KITTITAS COUNTY

MEMORANDUM

TO: All Staff
FROM: Public Works Plan Review Team
DATE: March 19th, 2024
SUBJECT: Public Works Comments: VA-24-00001 Burke

SITE PLAN
#22055

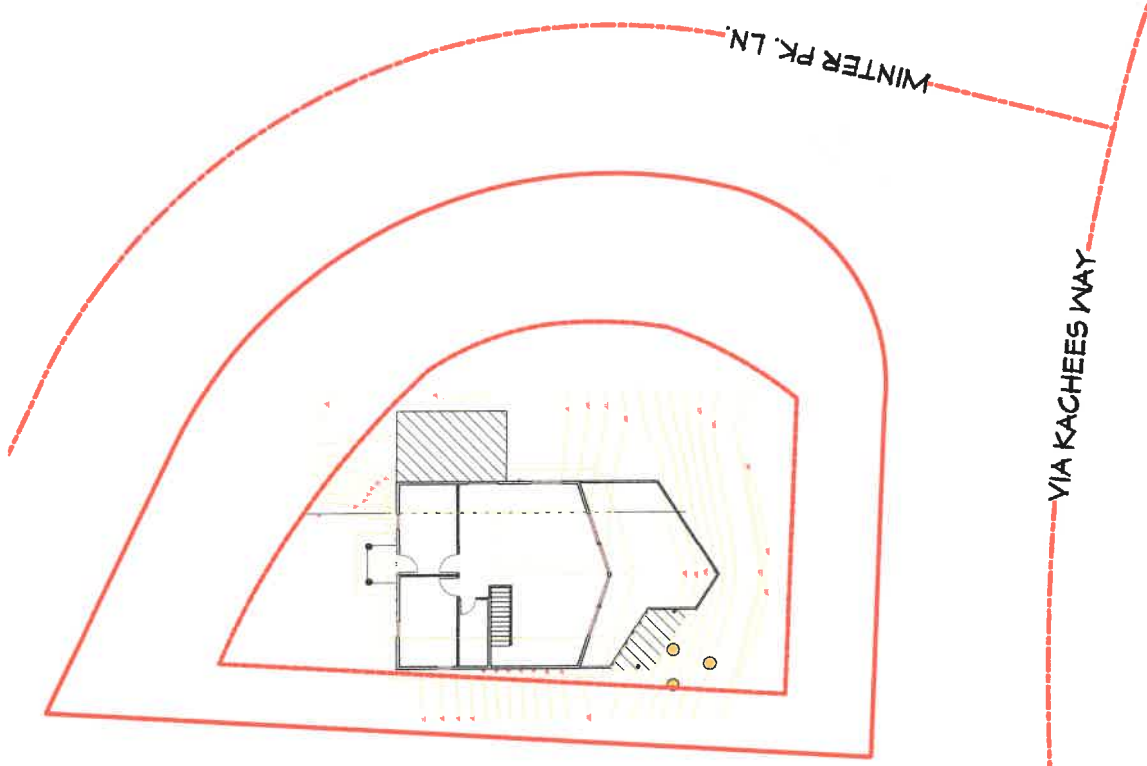
ACCESS	Applicant has an approved access permit is on file with Public Works (2004-650). No additional access comments.
ENGINEERING	Public Works is concerned that sight distance may be compromised with the additional overhang based on the site plan. The site plan does not provide enough information for this to be determined. Applicants should submit a site plan showing the edge of asphalt on Winter Park Ln and Via Kachess Rd, as well as the proposed improvement. Public Works would also accept a stamped plan from a licensed engineer verifying site distances, as described in Exhibit 1260-1 of the WSDOT Design Manual, are met.
SURVEY	The provided Site plans do not address how the boundaries (and subsequent setback lines) were determined. Based upon the road monuments located by the county in 2019, it appears that the existing house may already actually fall just 10 feet from the boundary line. Adding the proposed overhang would be a zero setback rather than a 15 foot setback. County survey strongly recommends a private land surveyor prepare a site plan prior to approval OR a private land surveyor is utilized during construction to ensure that revised setbacks are not encroached. (JT)
